Substitute plan for BR/298/19/PL

Further to my email earlier today, please find attached the revised site plans drawing, no. 6183 DP101A, showing the smoking shelter relocated to the South East of the site where its impact on neighbouring properties will be reduced.

I am the case officer on your application BR/298/19/PL at Homebeech Nursing Home , Bognor Regis.

DP101A

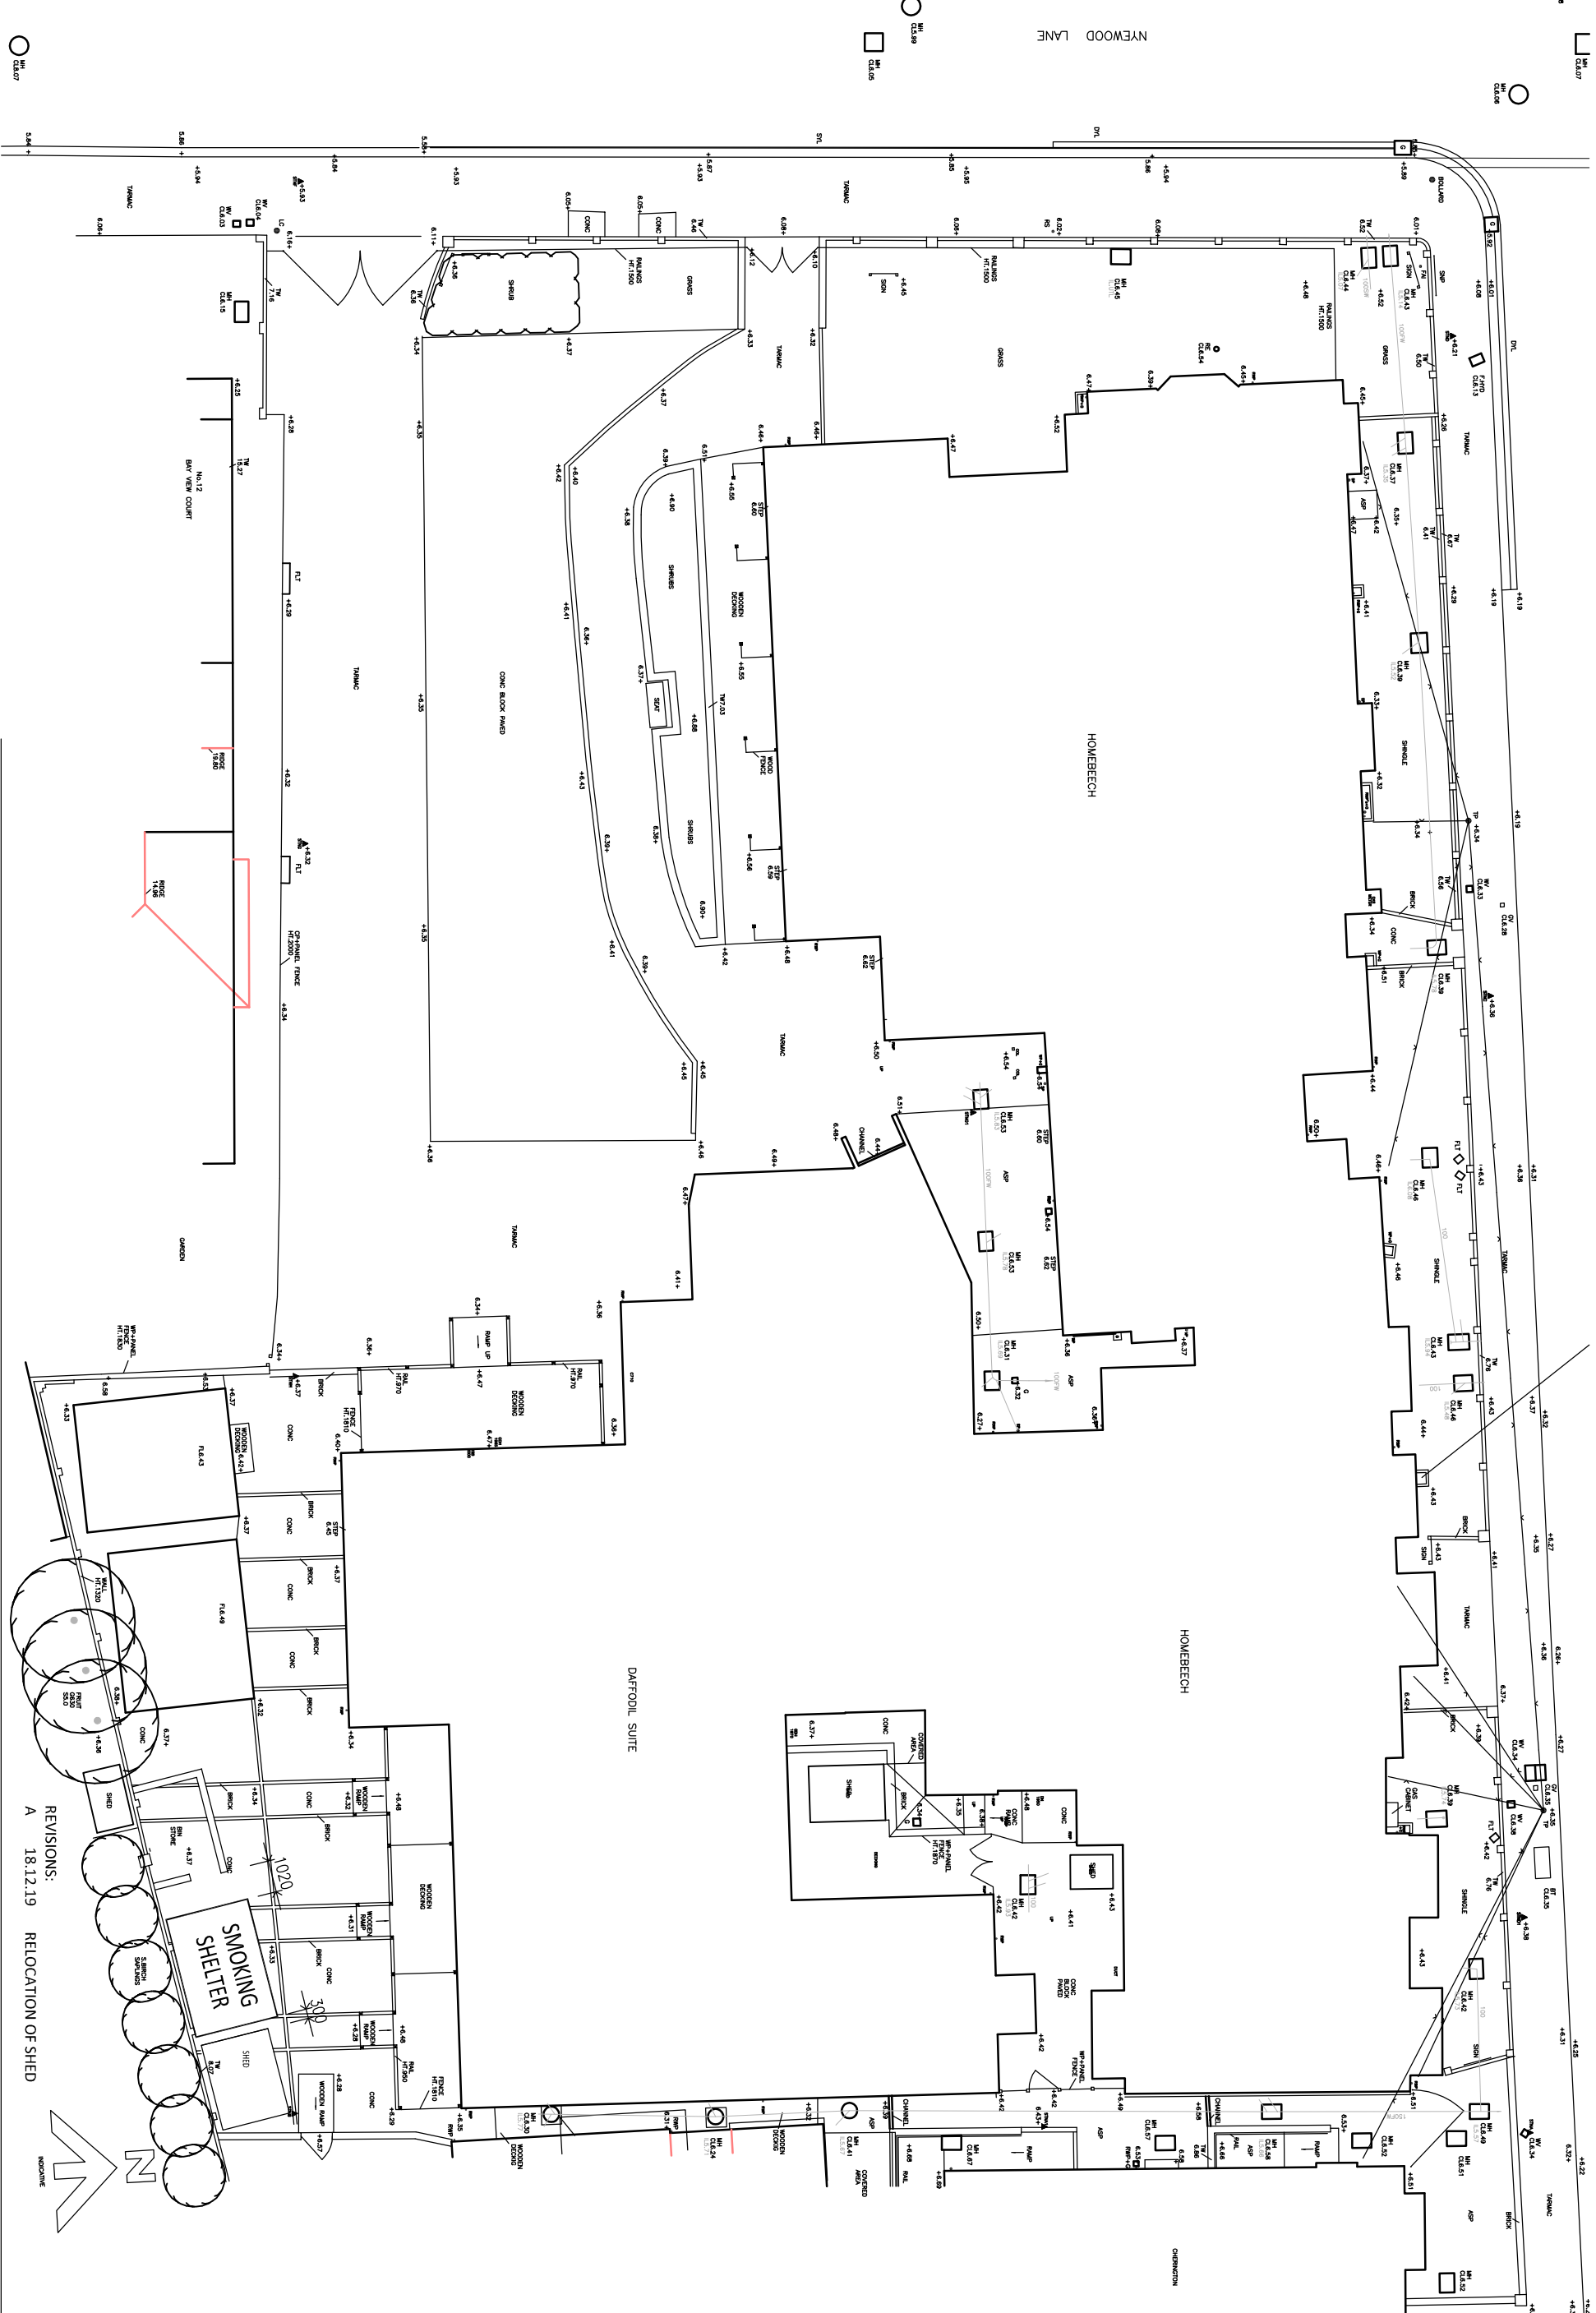
Unfortunately on discussions with my manager, the application is set to be refused due to its impact on the neighbouring occupiers at the adjacent flats.

I am writing to see if you would be willing to move the shelter to another location whereby the impact will be reduced. Please let me know if this is something you would be willing to do or alternatively it can be appealed.
